**Application for a non-material amendment following a grant of planning permission,
Town and Country Planning Act 1990**

**Non material amendment to previous permission 2020/90417 for erection of single
storey extension**

1, Rose Mount, Birkby, Huddersfield, HD2 2BU

Application Number: 2021/91567

West Elevation_existing

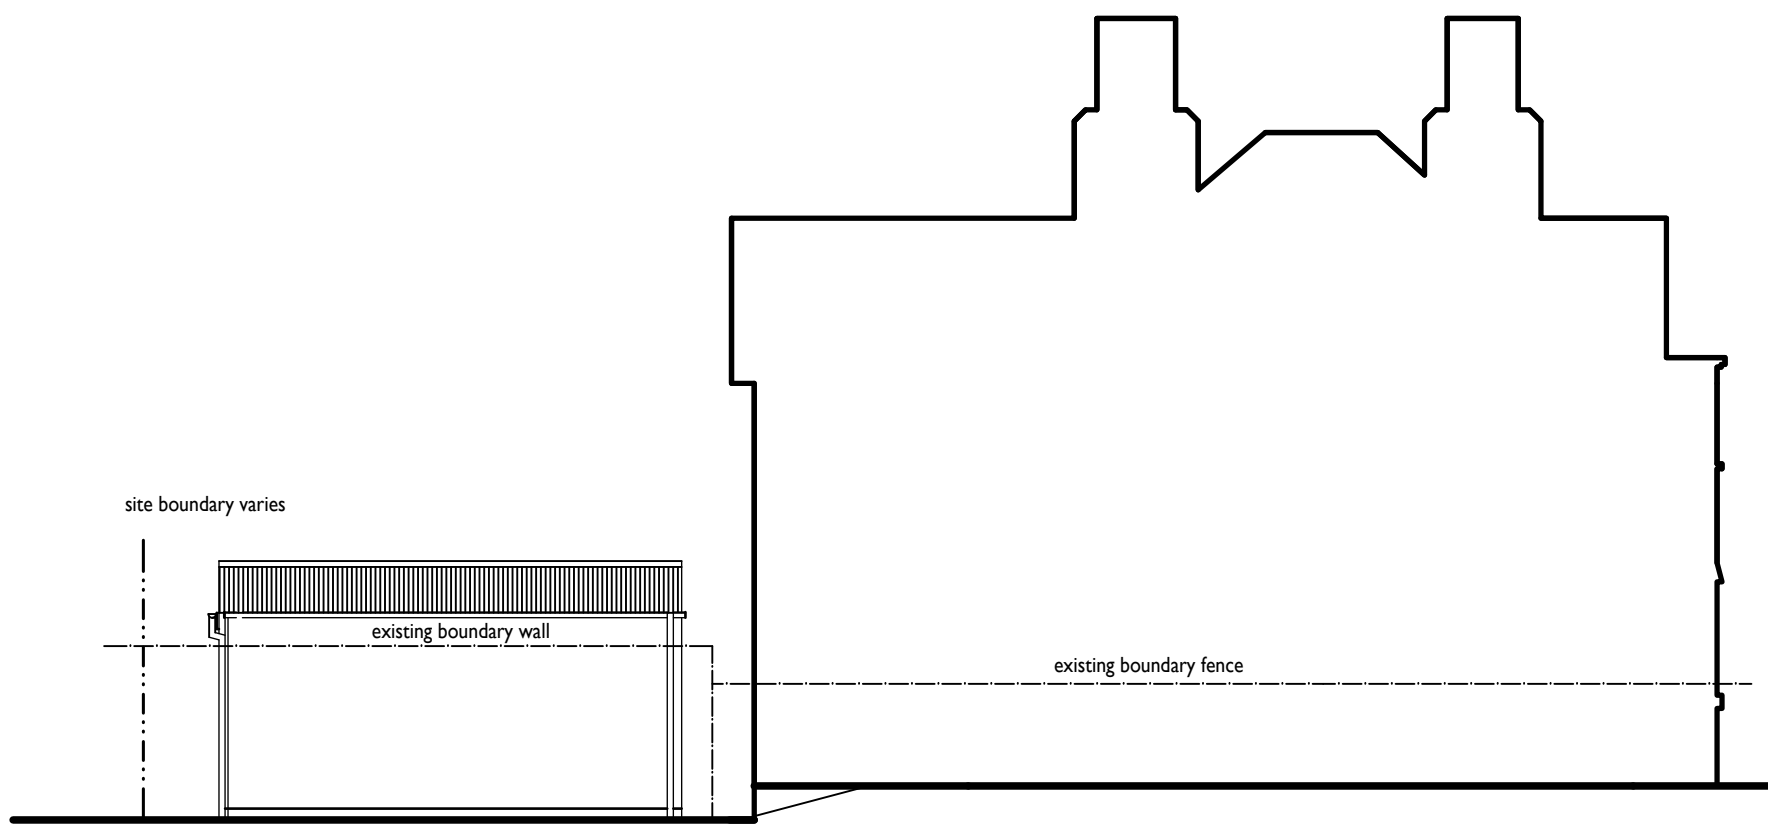
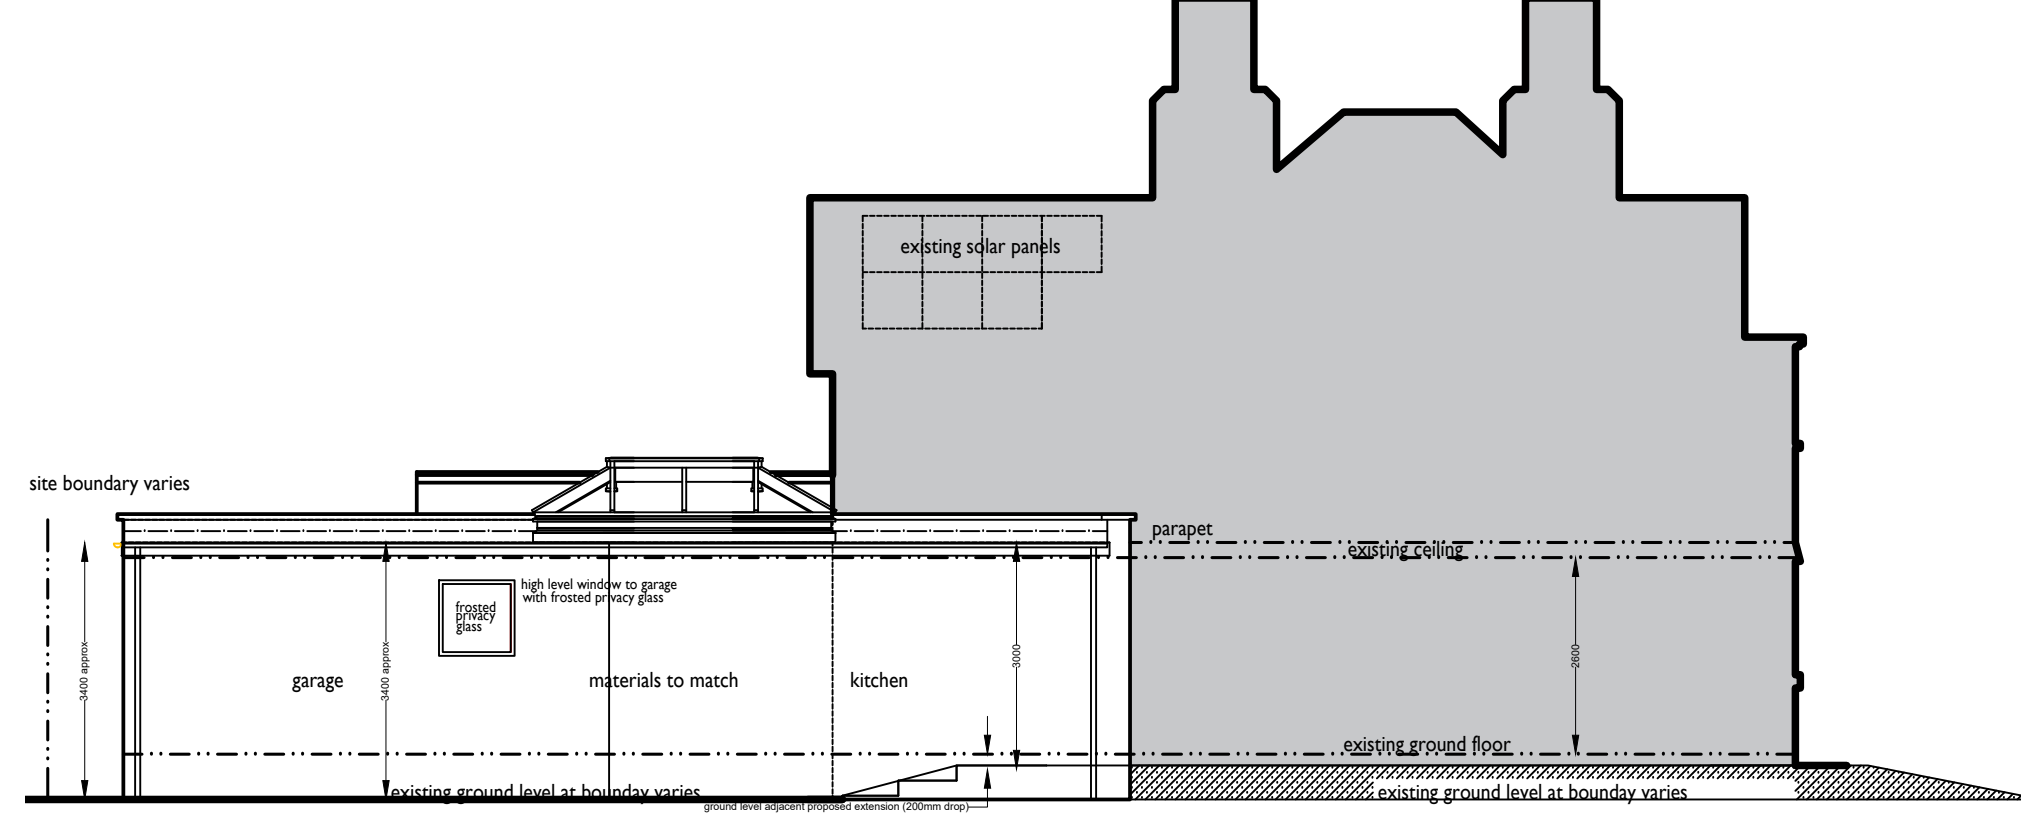
The amendment sought is for a longer roof lantern within the kitchen, a small set back to the rear wall of the garage and also a small pitch to the front of the garage roof as shown on drawing numbers Revision 01 Existing and Proposed Elevations and Revision 01 Existing and proposed Floor Plans.

Please note: This permission does not extend to the additional window openings within the side and rear elevations of the garage.

I confirm that the alterations are acceptable and may be considered as a non-material amendment to the approved drawings. It should be noted that this letter relates only to the non-material amendment sought and it is not a re-issue of the original planning permission. The two documents should be read together and as such, all conditions imposed on the original granting of planning permission apply to the proposal as now amended. A copy of this letter and the amended plans will be retained on the public record of approved documents.
